# STERLING RANCH FILING 4

# GRADING AND EROSION CONTROL PLANS

NOVEMBER 2022  
PCD FILING NO. : SP-22-030

STERLING RANCH FILING 4
 GRADING & EROSION CONTROL PLAN
 SHEET 2 OF 10
 JOB NO. 25188.11

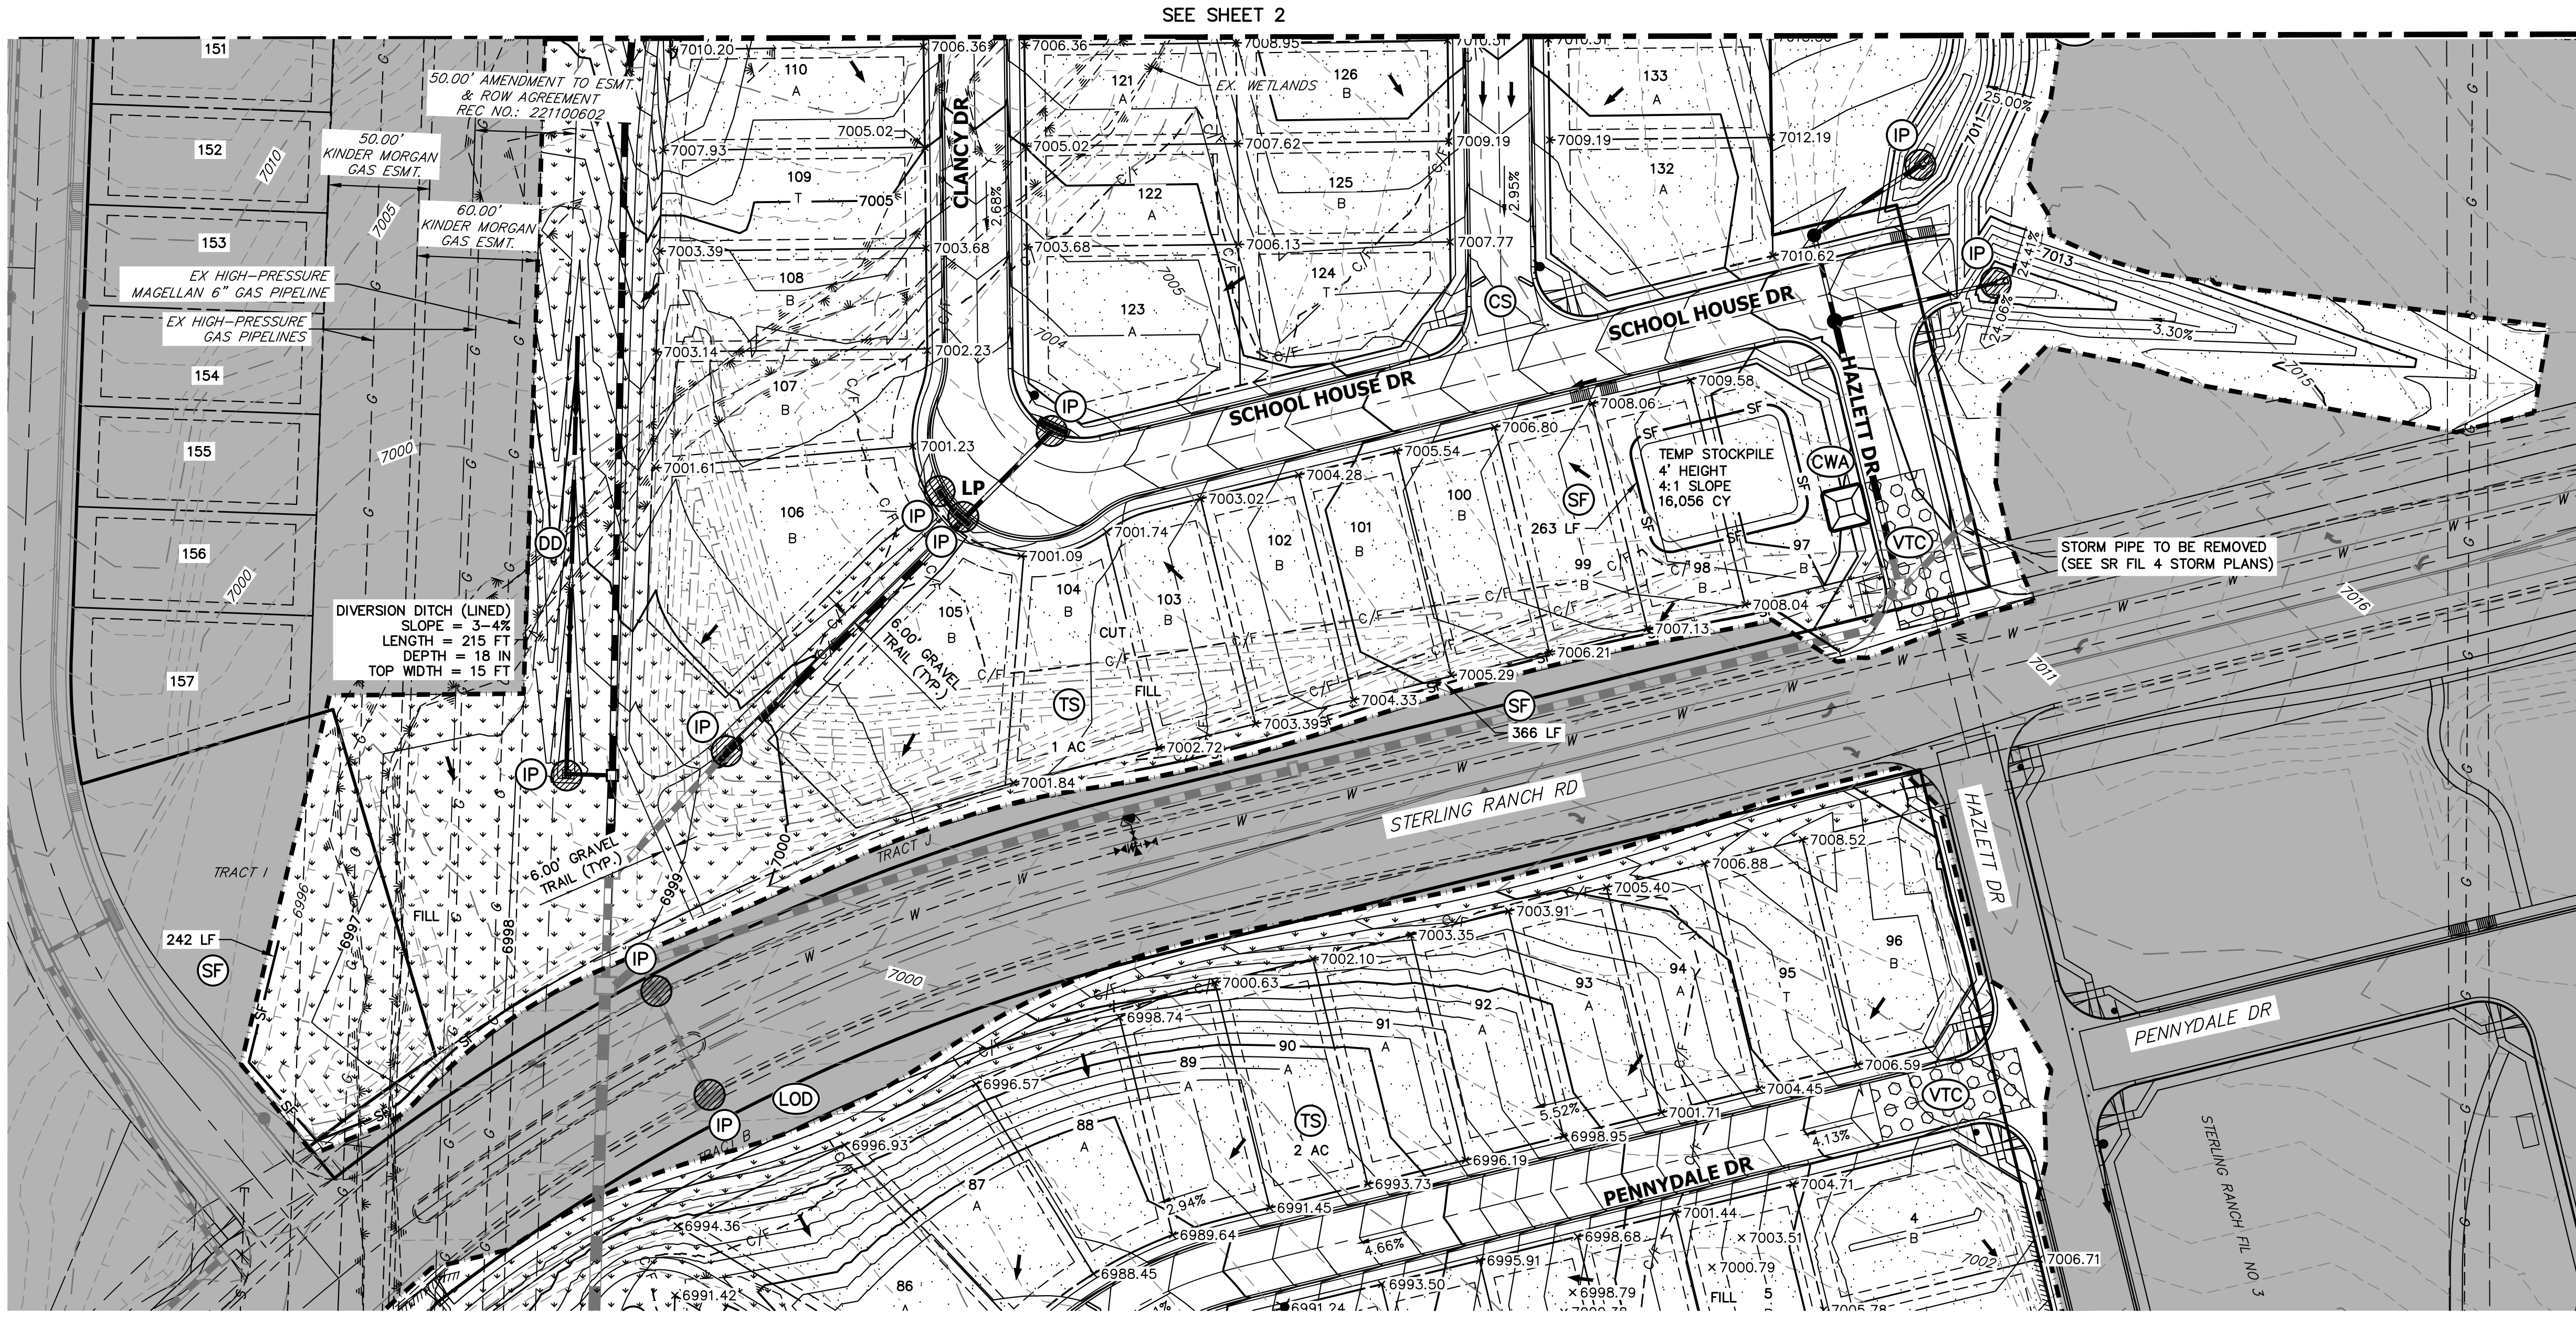
This grading is different from the previous submittal. Move the viewport limits over to the right to include entire limits of proposed grading area.

JR Engineering:  
Viewport limits adjusted.
